21/00517/F Wroxtton MX track.

Response to Charlotte Watkins E-mail dated 28/06/2021

The Ecological Enhancement Scheme June 2021:

Figure 1: Map of On-site Habitat Enhancement Proposals

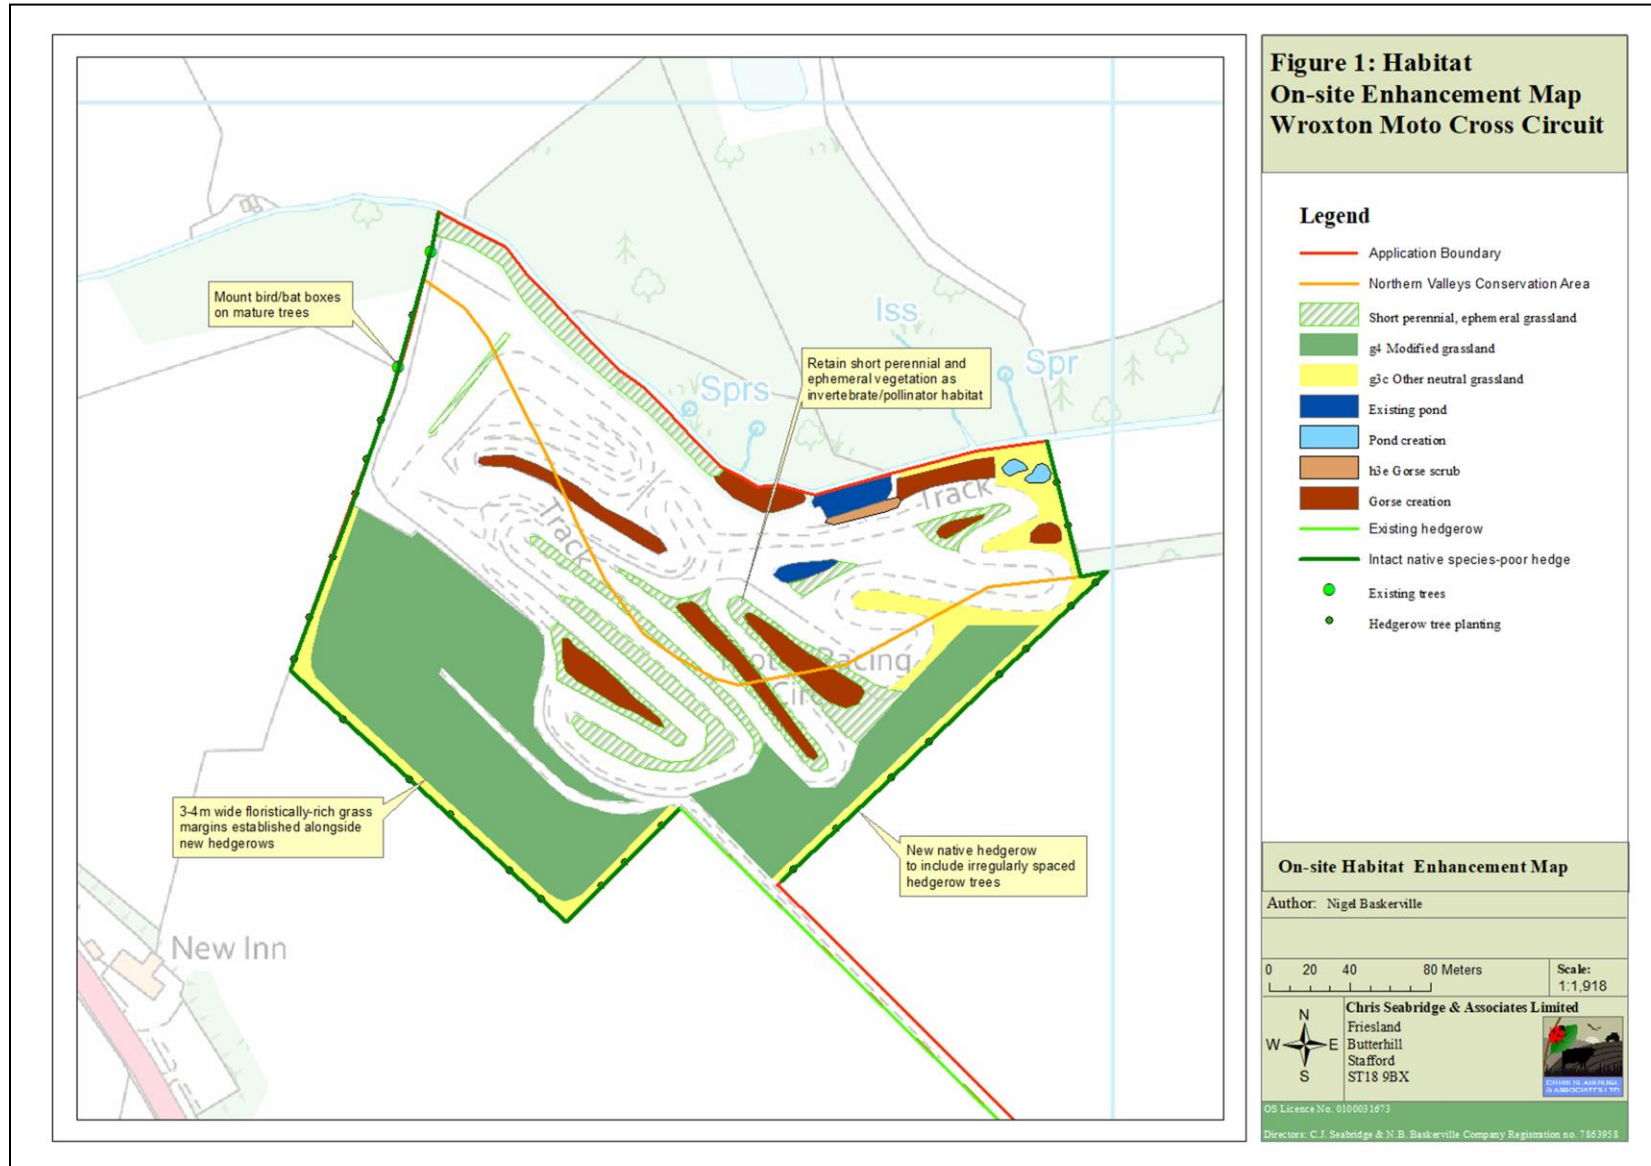
The additional hedgerow proposed to be planted is acceptable in terms of species. There is nothing on ongoing management in terms of frequency of cutting and height.

In order to ensure there is a chance of the hedgerow being a successful habitat and in particular the proposed floristically rich margins there will need to be installation of some sort of (wildlife permeable) fence or knee rail to ensure there is no walking or driving/parking close to the hedge or within the margin proposed.

3- 4m wide (and it doesn't say which – it should because an extra metre along this length of hedgerow would dramatically change the net gain achieved) is too narrow to ensure the hedgerow is fit for use by wildlife. With vehicles parked as close as this or potentially earthworks and large machinery this close the hedgerow roots would be impacted. A buffer of 10m to the hedgerow should be maintained where possible. The tree officer could advise further on this also.

It is unclear from the metric data supplied whether they count the areas to be camped on with camper vans and parking for vehicles/trailers as G4 modified grassland or whether these areas are counted as lost (which they probably should given the weight of traffic to be regularly on it?)

At least one of the areas proposed for small scale woodland creation appears to be on a very steep slope surrounded by track and skid marks. I am not convinced that this would be very successful for trees to survive or reach their natural size in terms of root protection zones? Again I would advise checking with the tree officer or landscape officer as to the likely success of this choice of site but I doubt anything beyond poor condition could be achieved.

- **Hedges would be allowed to grow up to a height of at least 2m and be trimmed every other year during January/February to allow the winter berry crop to be available to birds and other wildlife.**

- **I agree that a barrier such as a knee rail would be beneficial in preventing damage to the hedgerow margin**

- **Obviously the wider the margin, the more beneficial it will be for wildlife, but a 4m wide margin will still be able to support a range of typical flora and fauna associated with the**

hedge bottom and I disagree that it would not be fit for use by wildlife. A tree root protection zone of 10m would seem to be excessive for a hedgerow given the likely diameter of the stems of the shrub species.

- **The camping area is counted as G4 modified grassland. Since this habitat will not be destroyed, it has not been counted as lost.**

- **Shrub species would form the margin of the woodland to create a more graded edge with larger trees within the middle of the plantation, planted further away from the track.**
